From: Zac Denton
Sent: 30 November 2017 15:21
To: Planning.Responses
Subject: FW: ref EG/86/17/T Trees TPO 170

Planning application your ref EG/86/17/T Trees TPO 170

131 FARNHAMST ROAD

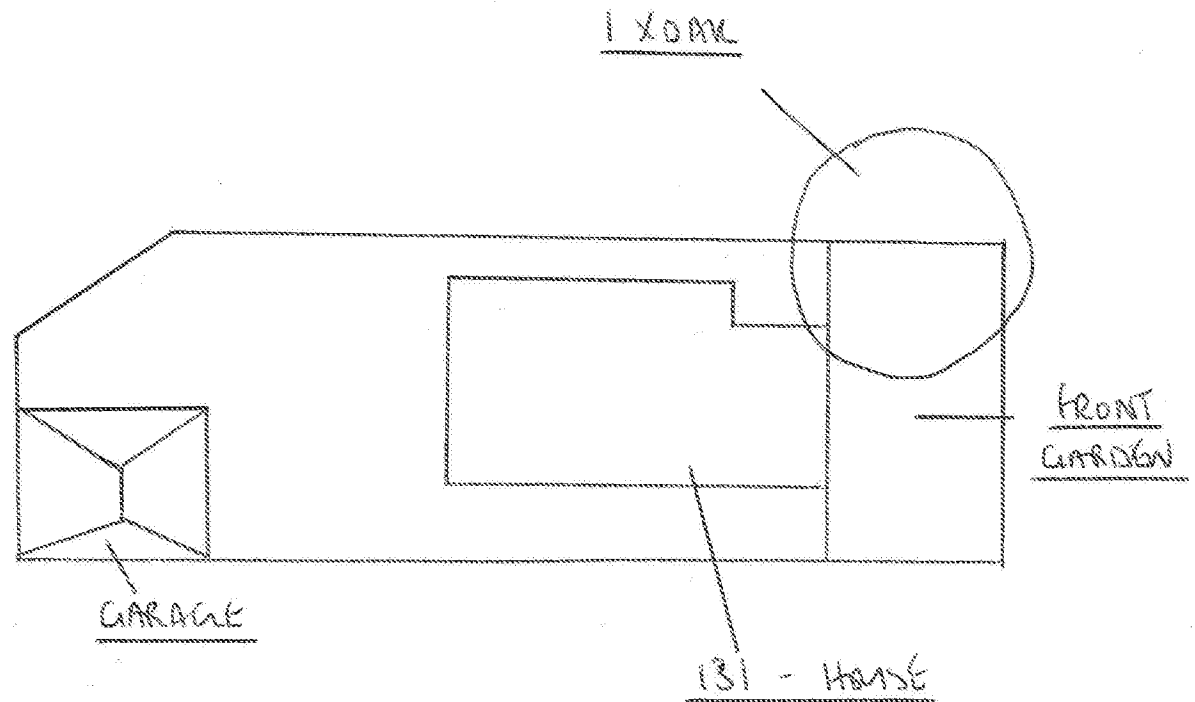
- 1 There are no trees on the property at 131 Farnhurst Road
- 2 The trees are on the property of 133 Farnhurst Road
- 3 There are three trees at 133
- 4 Mr David Barnes which you state you state lives at 129 Farnhurst Road in the application as being the owner, lives at 133 Farnhurst not 129

Which trees are you referring to as I have not been notified of tree felling. I have given my permission to Mr Ben Horsman of 131 to trim the tree at the Southern end of a group of three. I have written (confirmed in writing and copied in Arun District council on the 1-10-2017 that Mr B Horsman can trim the trees if he wishes and remove the large bough branch that overhangs his property if he wishes to subject to Arun approval at his expense. Not touching any of the other two on the north side. I have not given my permission as to tree felling. Just trimming.

Although the planning application is in error. It is unclear as to which trees & what is planned either. Can you please specify.
